Householder Proforma

Application Ref: 2021/0788

Address: 14 Highfields, Hoylandswaine, Barnsley, S36 7JP

Proposed: Alterations to dwelling including raising of roof, addition of dormers, balcony and rendering of property

1 3D View 01

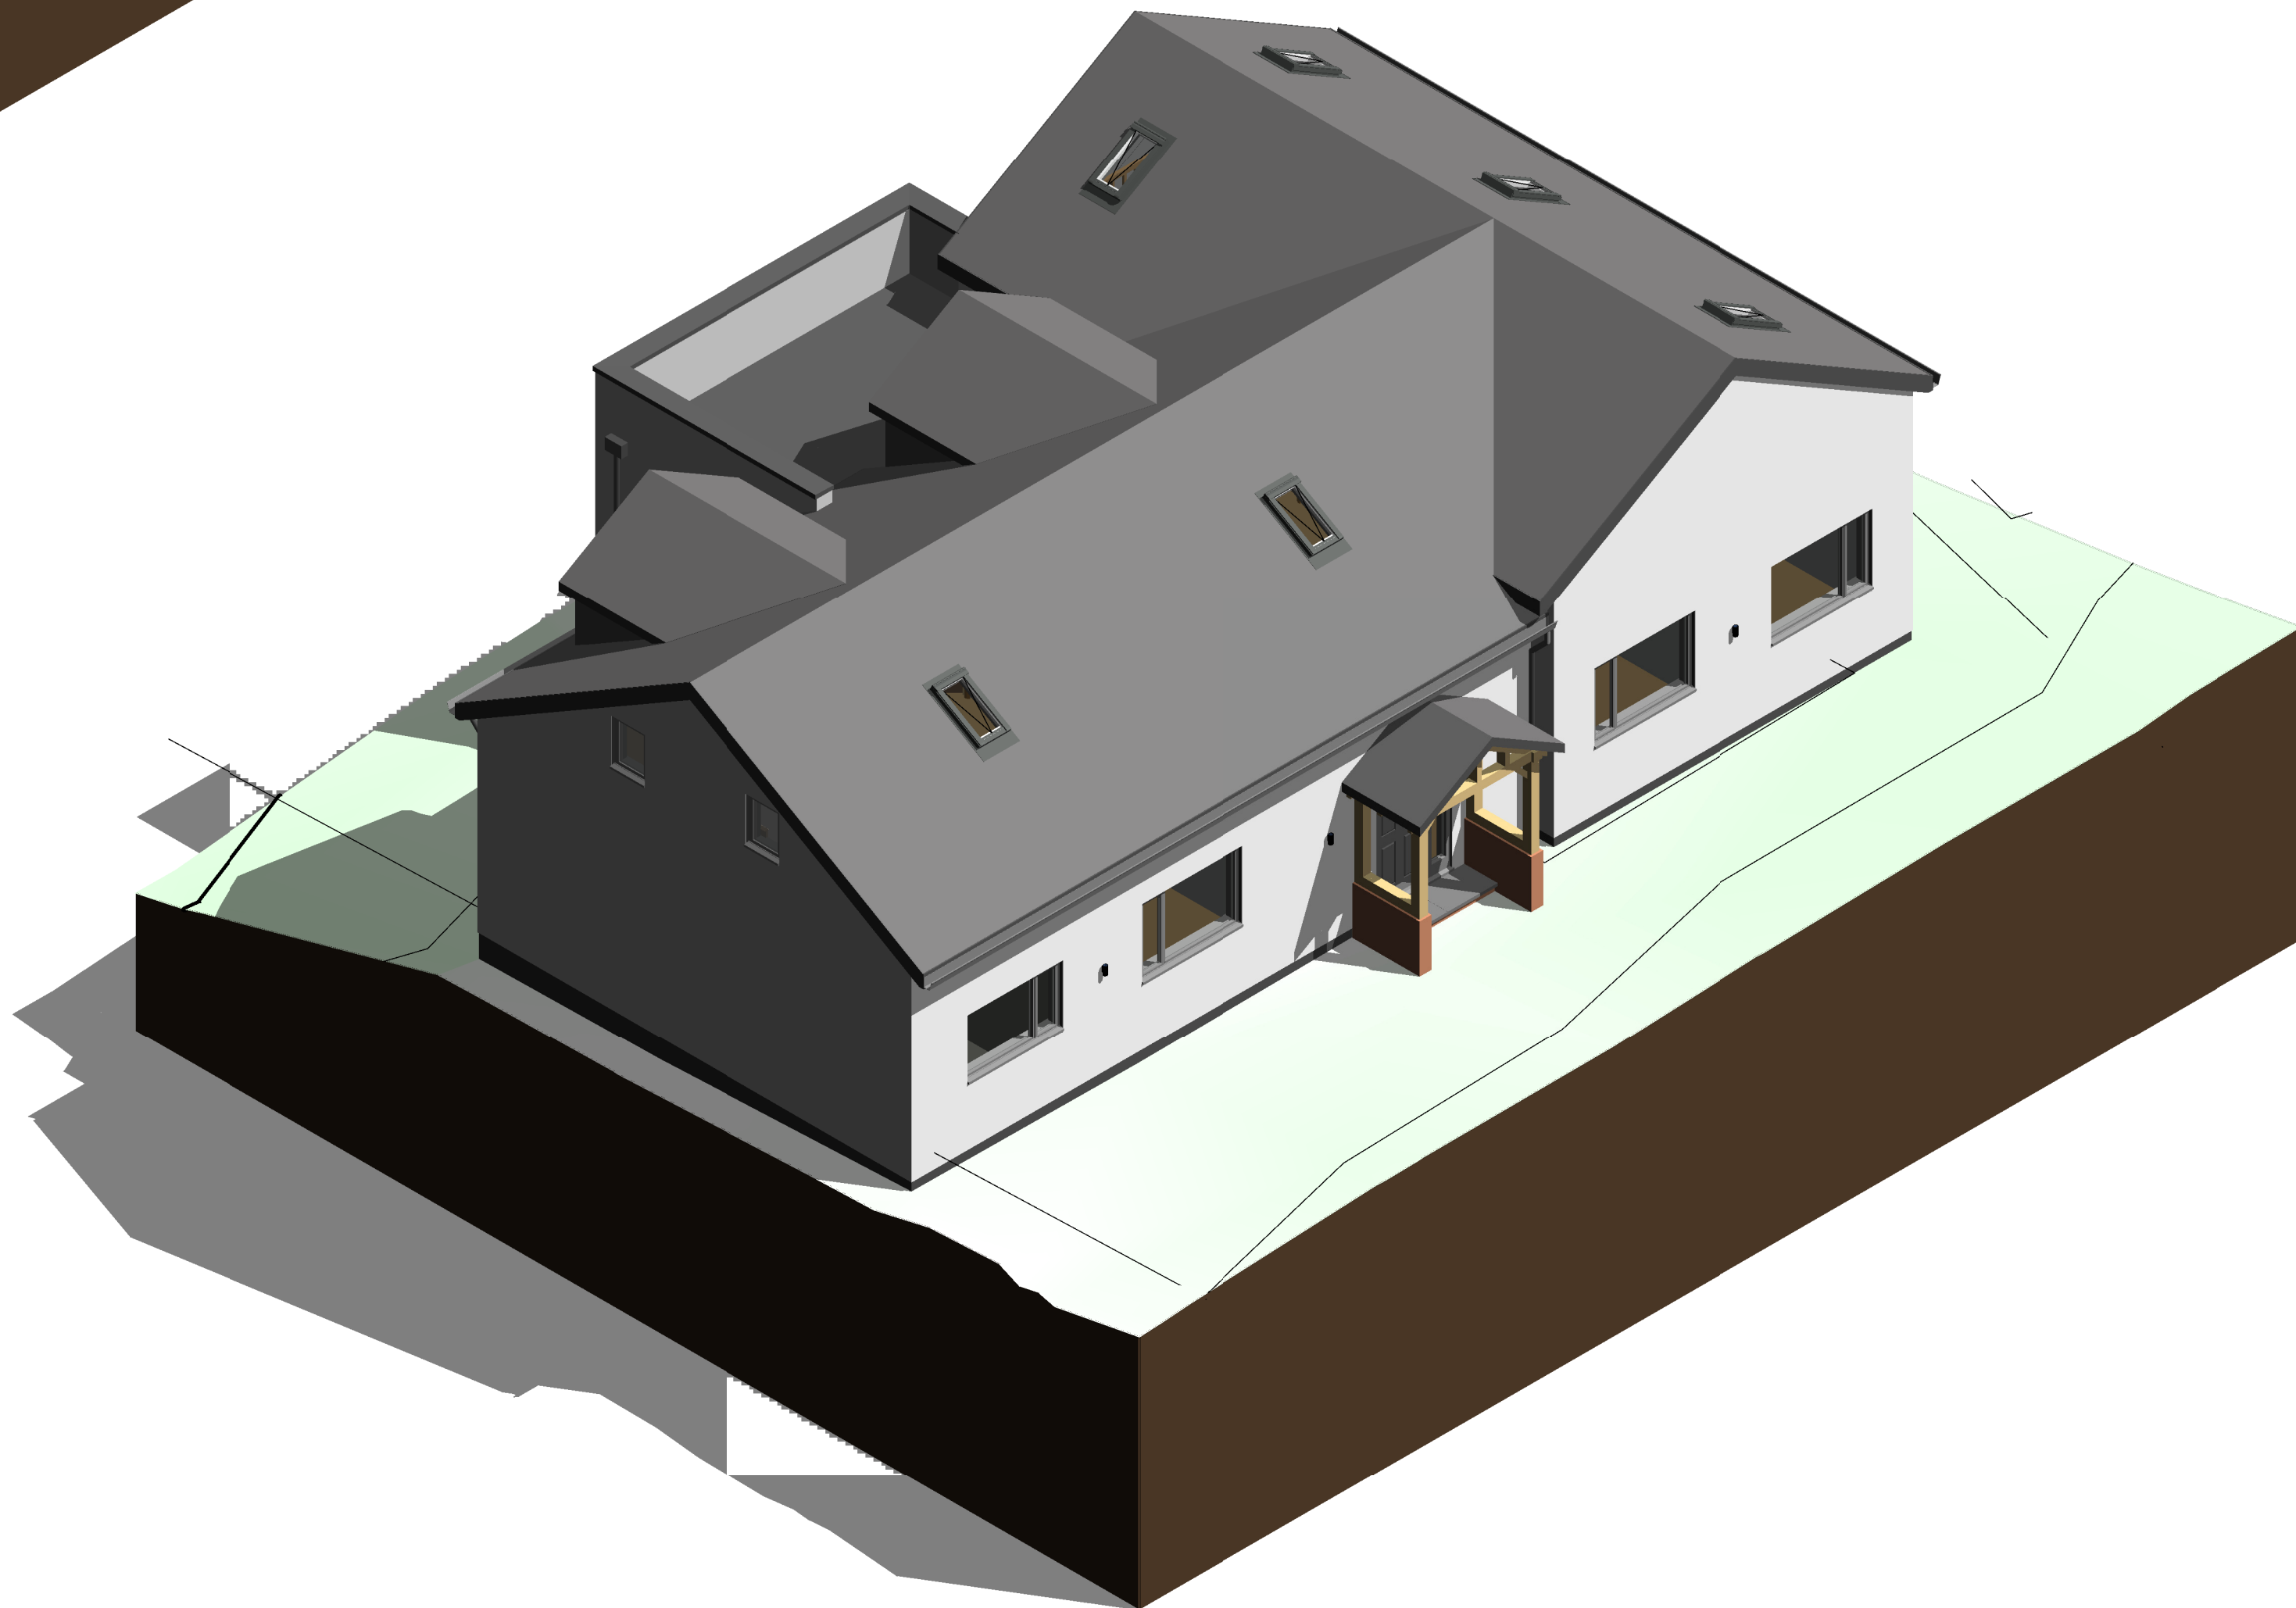
Single Storey	
1. terraced property and less than 3.5m (projection to rear)?	
2. semi-detached and less than 4m?	Existing rear extension – balcony proposed to this structure.
3. if more than 3m are the eaves more than 2.5m in height?	
Two Storey	
4. terraced property and less than 2.5m (projection to the rear)?	
5. semi-detached and less than 3.5m?	
All	
6. materials to match	The whole property will be rendered
7. roof design compliments / ties in well	Proposal for 1m wall to sides of existing extension to create balcony. Screening to west elevation which will protect amenity value of No. 16 garden area. The screening is proposed grey finish timber/composite
